Fire Risk Assessment

Common Areas and Services

**54 Montpelier Road
Brighton
BN1 3BA**

Date of Inspection: 3rd January 2024

REAR ELEVATION WITH FIRE LADDER

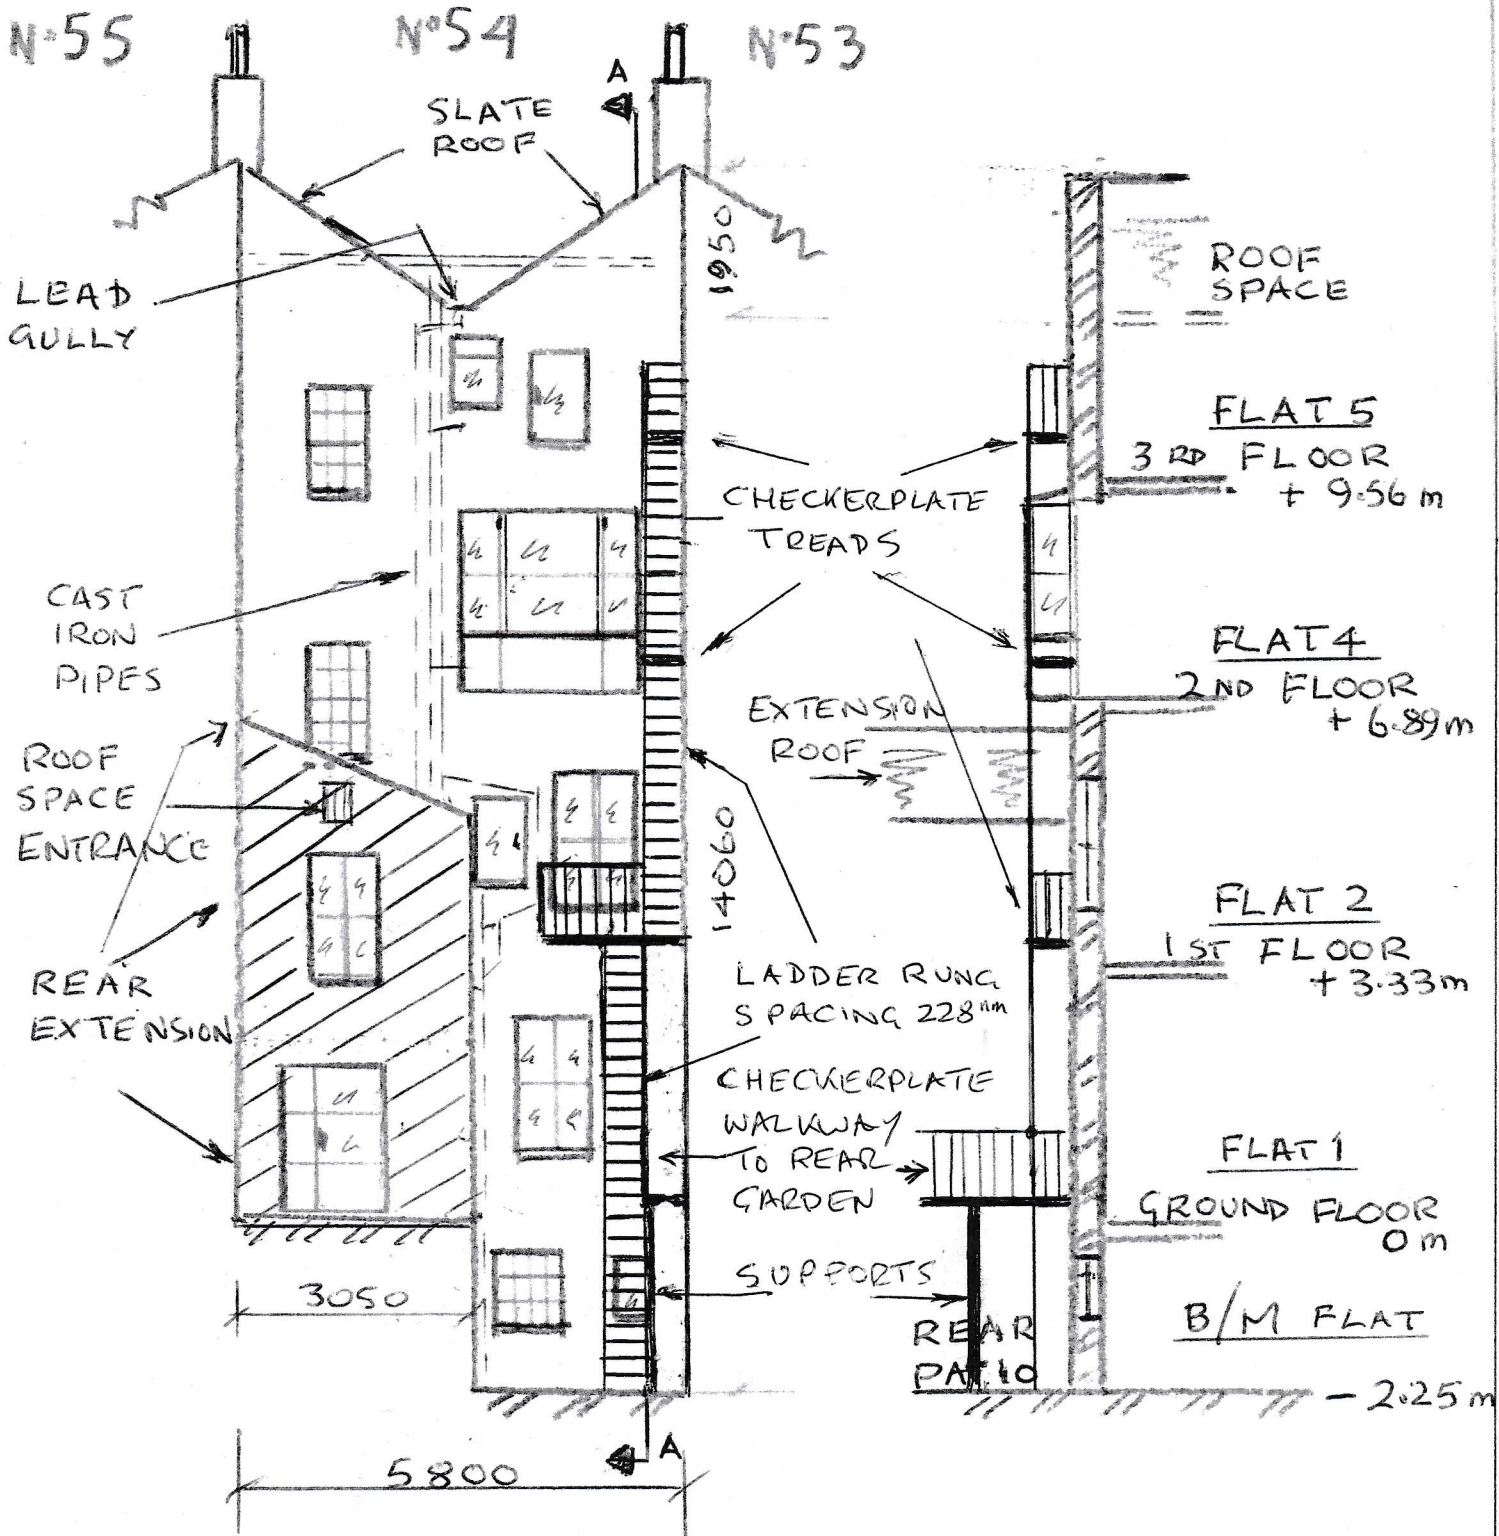
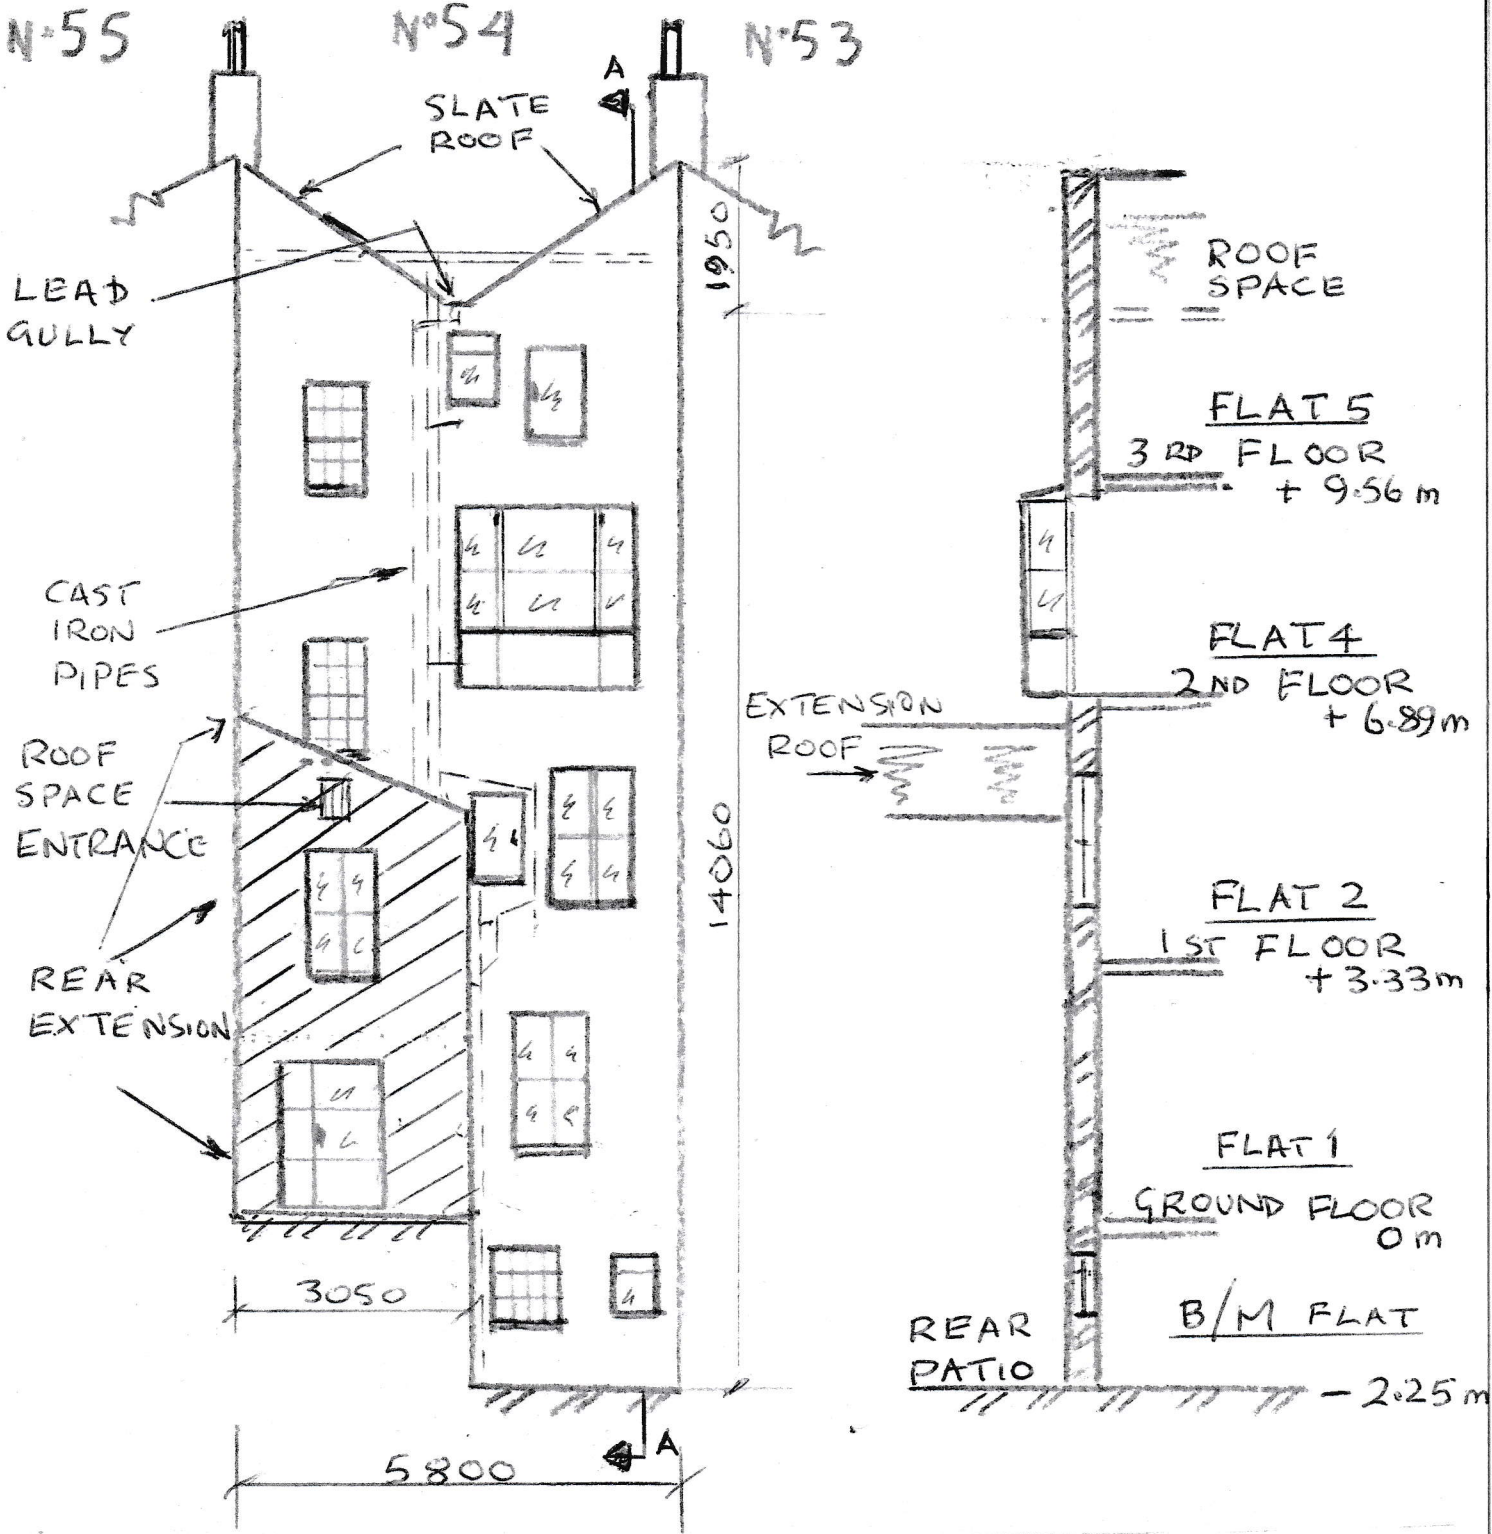
15.5	Comments and deficiencies observed:						
<ul style="list-style-type: none"> • Some exit doors open in; however this creates no problem as there is never likely to be in excess of 60 persons attempting to escape from the property at any one time. • The premises features a cast iron back to wall and platformed alternate means of escape on the rear external elevation. The structure was found to be in poor condition and corroded in many places. The rear escape discharged into an enclosed garden, with no final exit point. • Each floor was inspected individually and separate reports provided in section 27.

<p>6. External Escape Dangerous</p> <p>15.4 The external escape should be made out of bounds taped with red and white tape and signed as a dangerous structure. The external steps and platforms are rusted and in poor condition.</p> <p>External steel staircases, ladders, walkways, balconies and gangways which form part of the means of escape from the premises, should be examined by a competent person at appropriate intervals as recommended in the current British Standard BS 8210 <i>Guide To Facilities Management In Buildings</i>. Generally tests are 3 yearly and provided with a certificate that the structure is safe and in a satisfactory condition.</p> <p>Normally, if the structure is considered beyond repair then a process of removal will need to be implemented including planning and building control applications. This assessment would then require immediate review. Immediate action is required.</p>	1
